From: Joe Russell-Wells
Sent: 07 August 2014 16:01
To: Cian Cronin
Cc: Sue Howell
Subject: RE: Oldlands Farm (ref. BE/73/14/PL) - Updated Landscape Drawings

Title	Submitted Plan Ref.	Revised Plan Ref.
Hard Landscaping	1606-L02-02 Rev F	1606-L02-02 Rev J
Planting Proposals	1606-L02-03 Rev C	1606-L02-03 Rev F

- DLA-1606-L02-02 Hard Landscape Layout
- DLA-1606-L02-03 Planting proposals

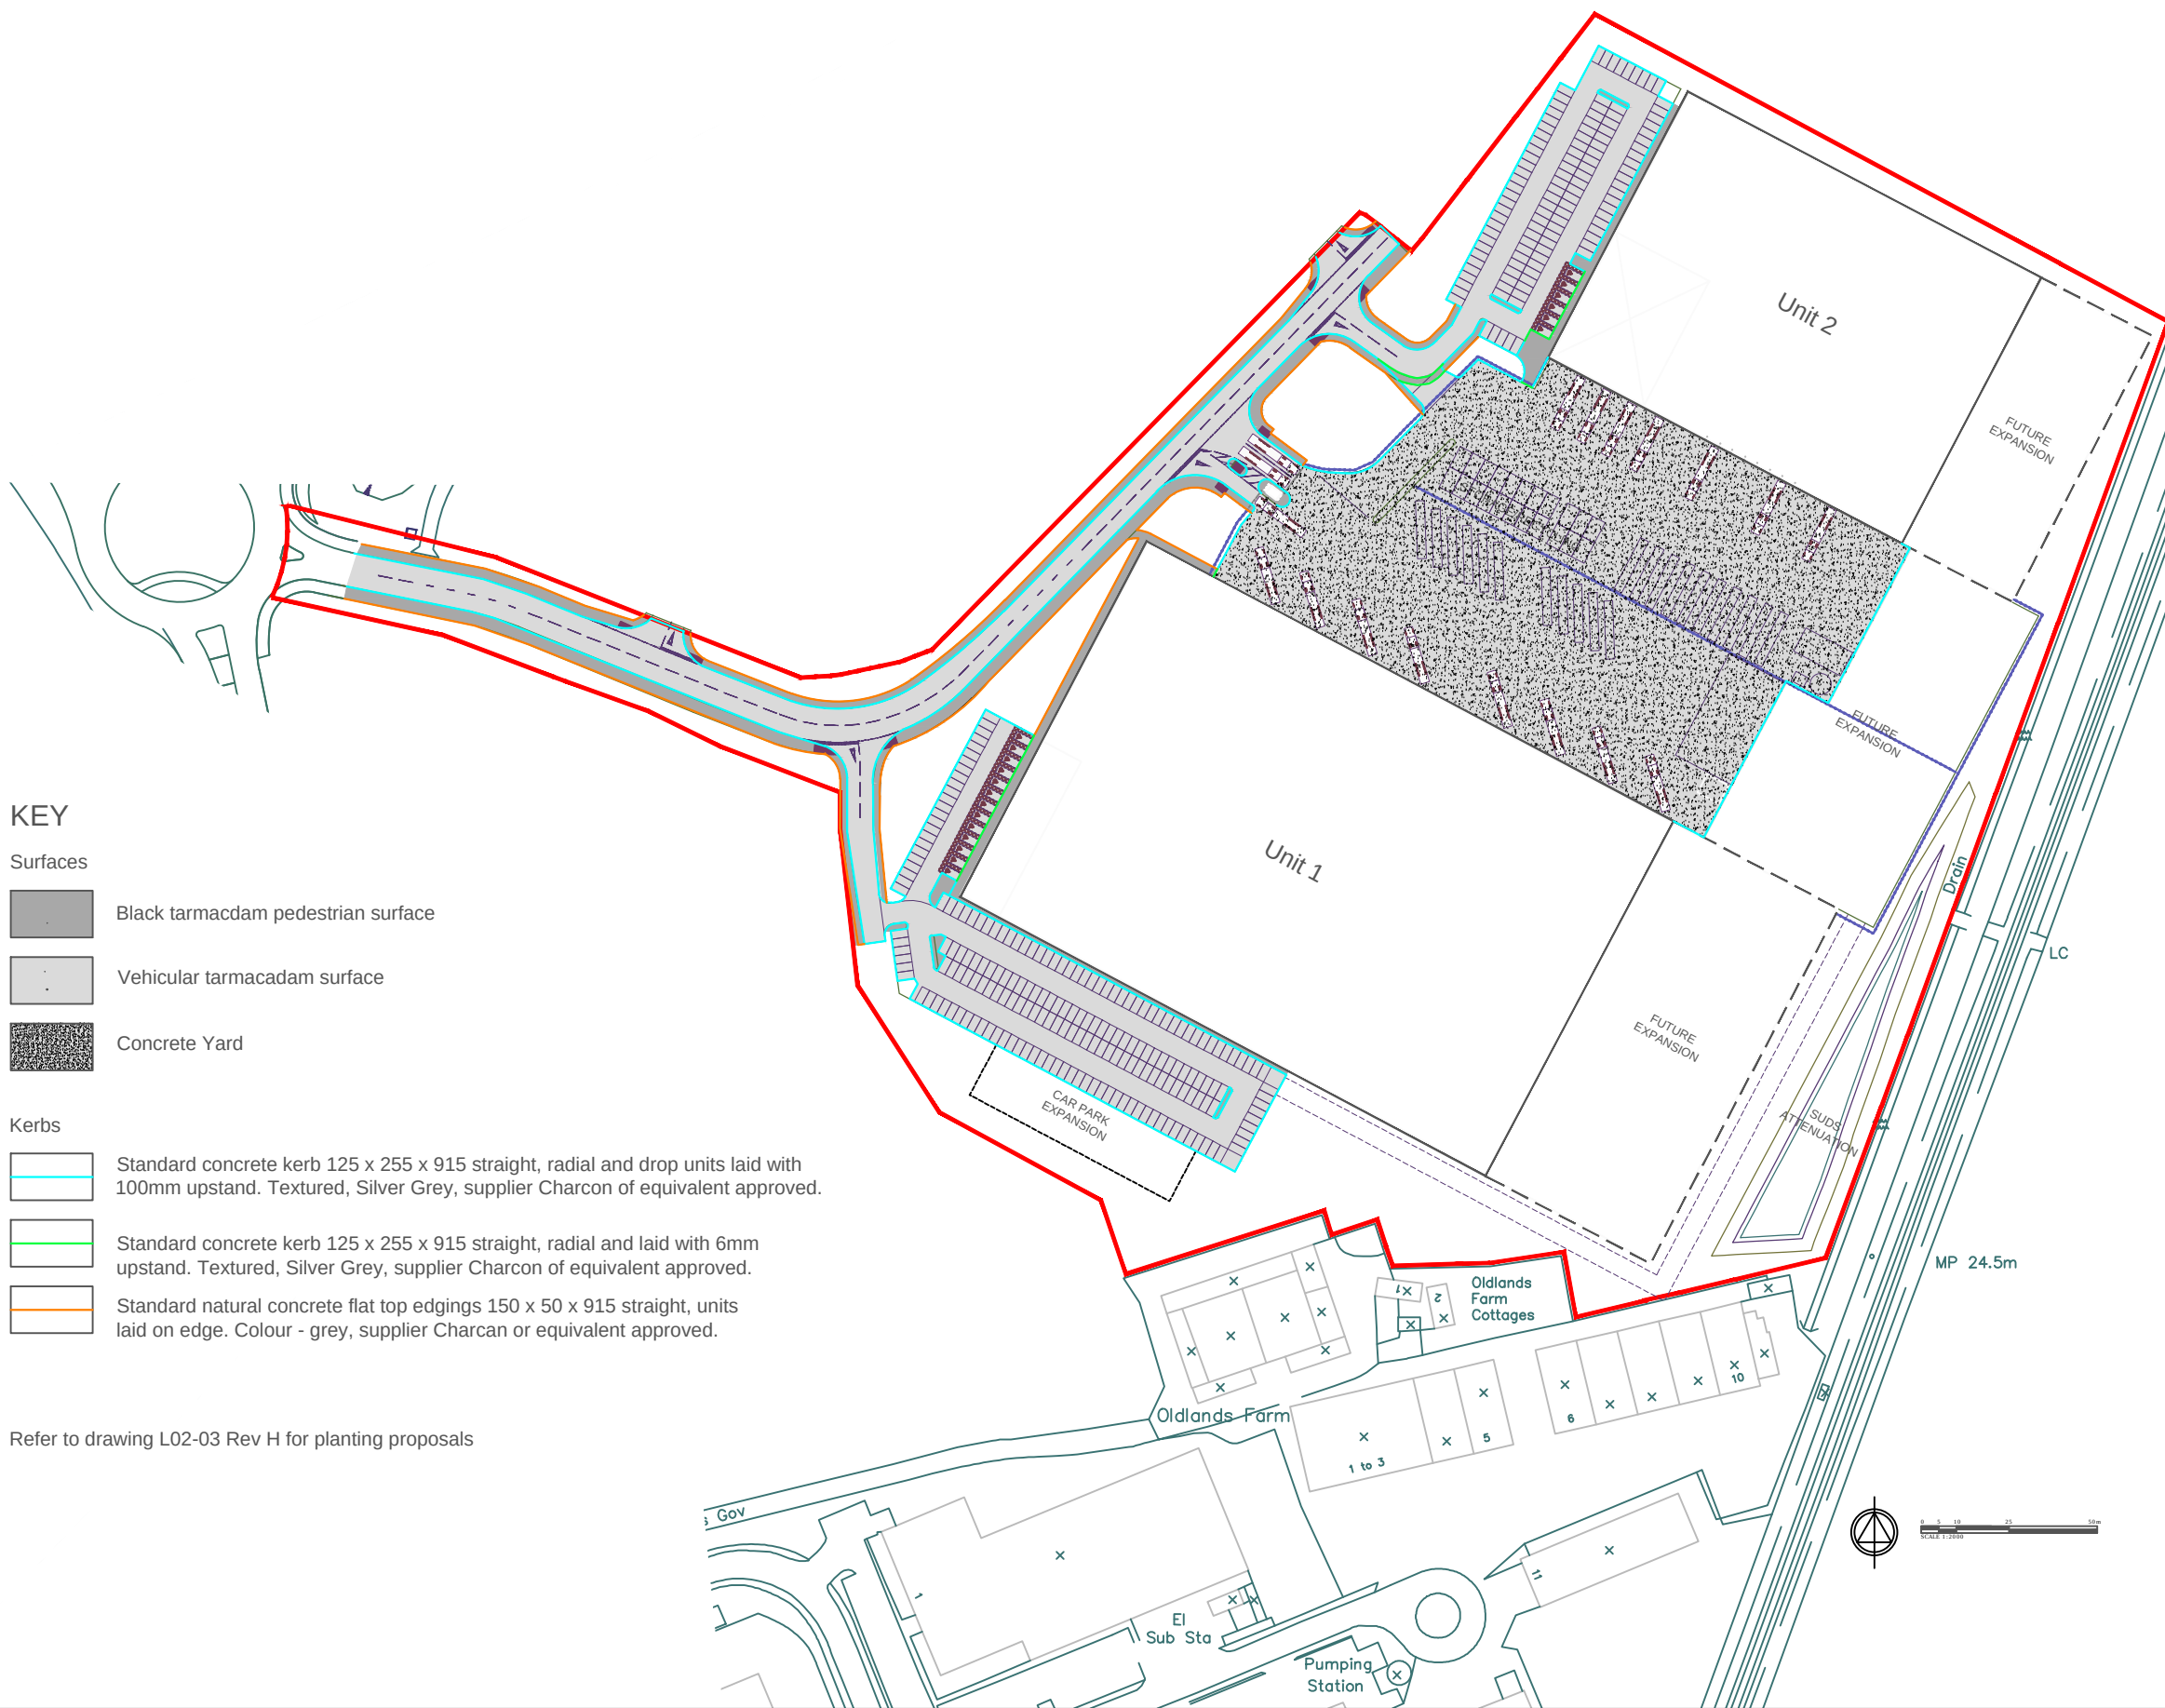
I note however that there is limited landscaping / screening along the railway side of the proposal between the proposed planning at the north and the SUDS area. In addition there is no screening proposed to the north of Unit 2 - any screening in this area will help to reduce the scale of the building. Similarly there is no landscaping proposed around or integral to the car parking areas. In each of these cases further planting should be provided to allow for improved screening and setting for the development.
